# **CITY OF ALBUQUERQUE**

RE: La Madeleines 2110 Louisiana Blvd NE Grading Plan (Stamp Date 2/2/17) and Drainage Report (Stamp Date 1/26/17) Hydrology File: J19D071B

Based upon the information provided in your submittal received 2/2/17, the Grading Plan and Drainage Report are approved for Building Permit.

ENGINEER'S SEAL	LA MADELEINE	DRAWN BY WCUJ
	GRADING AND DRAINAGE PLAN	DATE 1-26-17
		21634-LADOT-10-25-18
DAVID SOULE P.E. #14522	<i>Rio Grande Engineering</i> 1808 CENTRAL AVENUE SE SUITE 201 ALBUQUERQUE, NM 87106 (505) 874-0999	SHEET # C001
		JOB # 21634

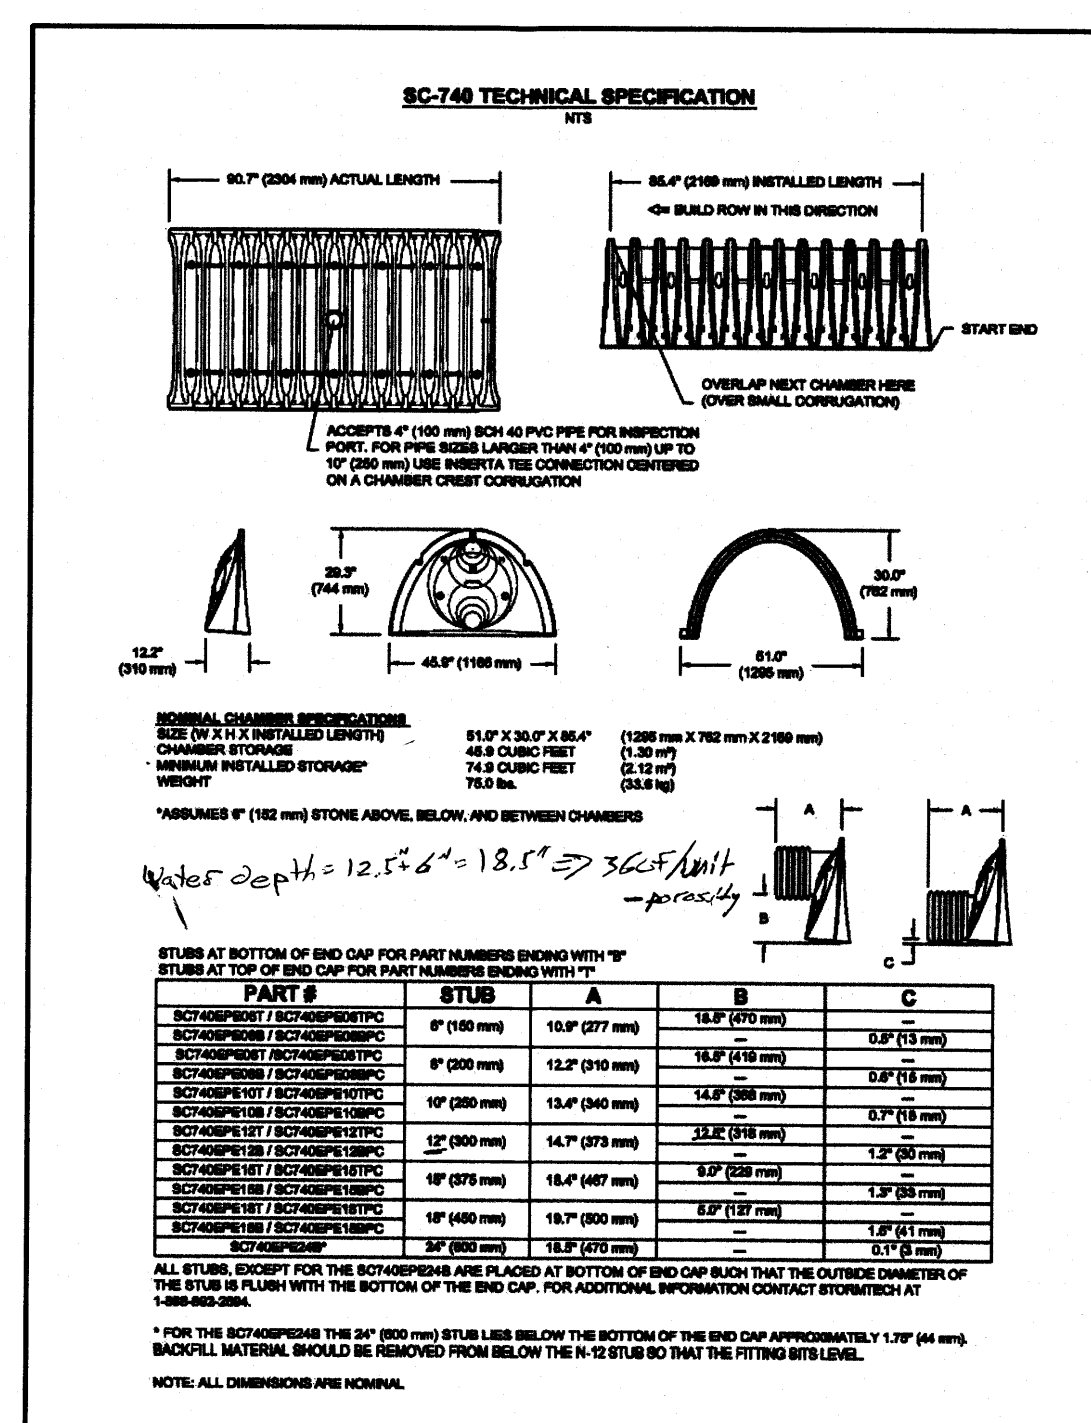
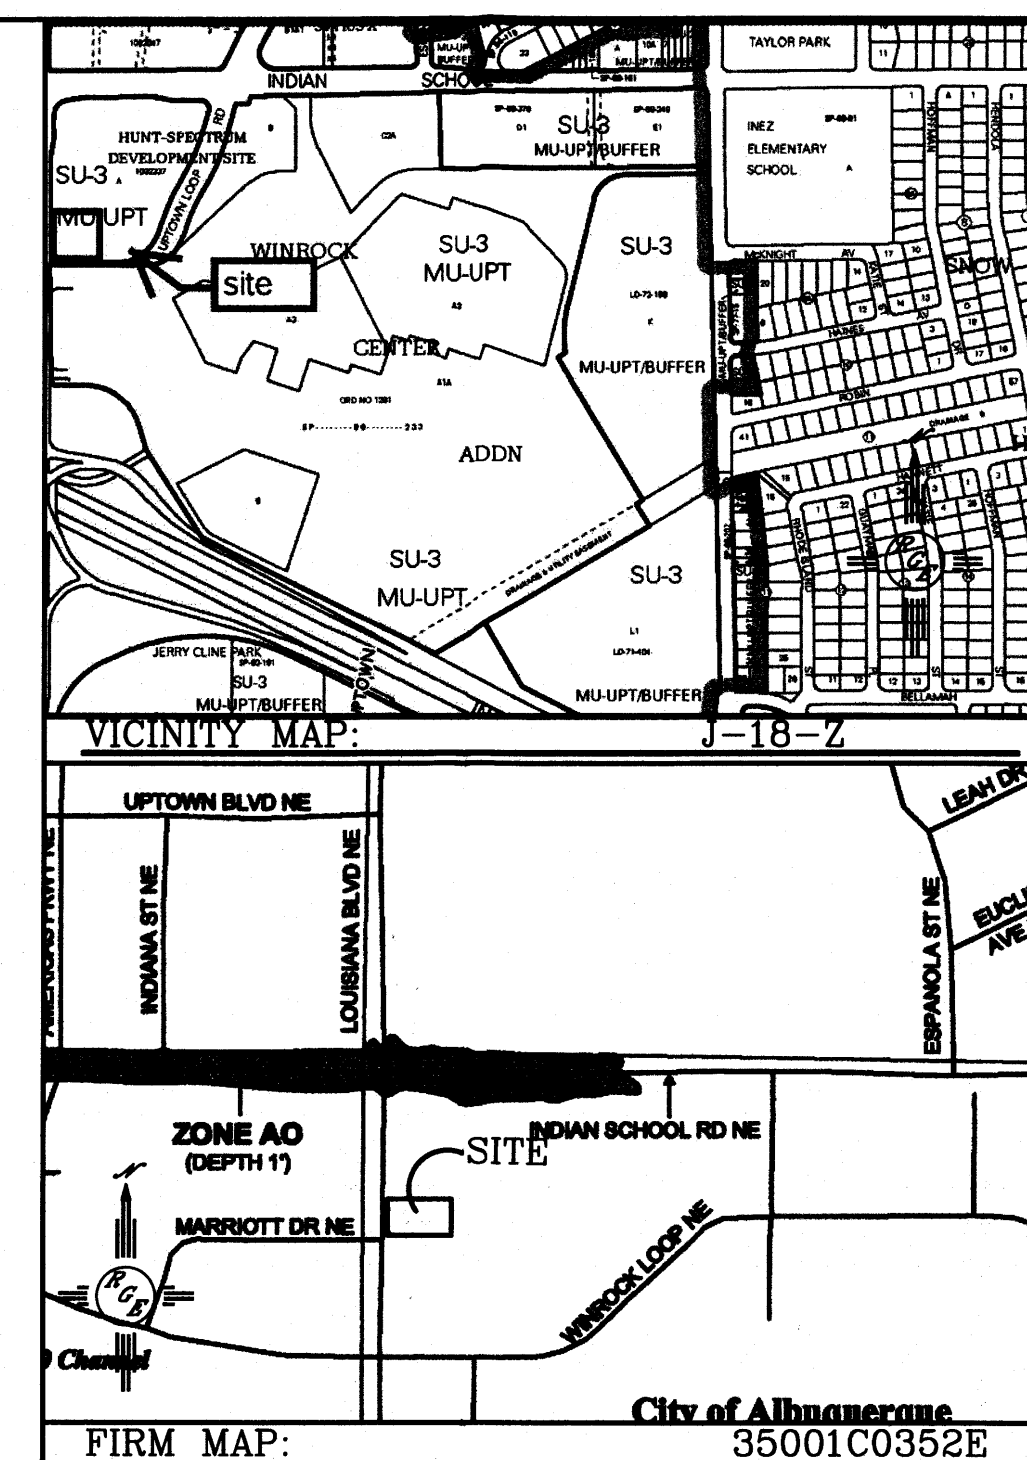
- The reissued Drainage Report is missing the 40-Ac or less Calcs (Appendix A) and several excerpts from the Target Drainage Study (Appendix B). These were included in the 1/3/17 report. we have added
- 2. The infiltrators do not retain the first flush volume:
  - a. StormTech assumes a stone porosity of 40% for in the cumulative volume storage. The City allows only 30% porosity for storage in the stone void space. The volume stored needs to reflect this. calculations have been revised
  - b. The volume stored needs to be calculated as the amount stored beneath the outlet pipe invert. i.e the volume that cannot leave through the outlet pipe.
    - calculation has been revised and cross-section shown
- 3. The Master Plan excerpts showing the grease trap and sanitary sewer routing were not included.

4. The first flush volume needs to be recalculated to only include the new impervious area.

<u>The calculation was based upon he improved area not the whole lot so the value is correct</u>
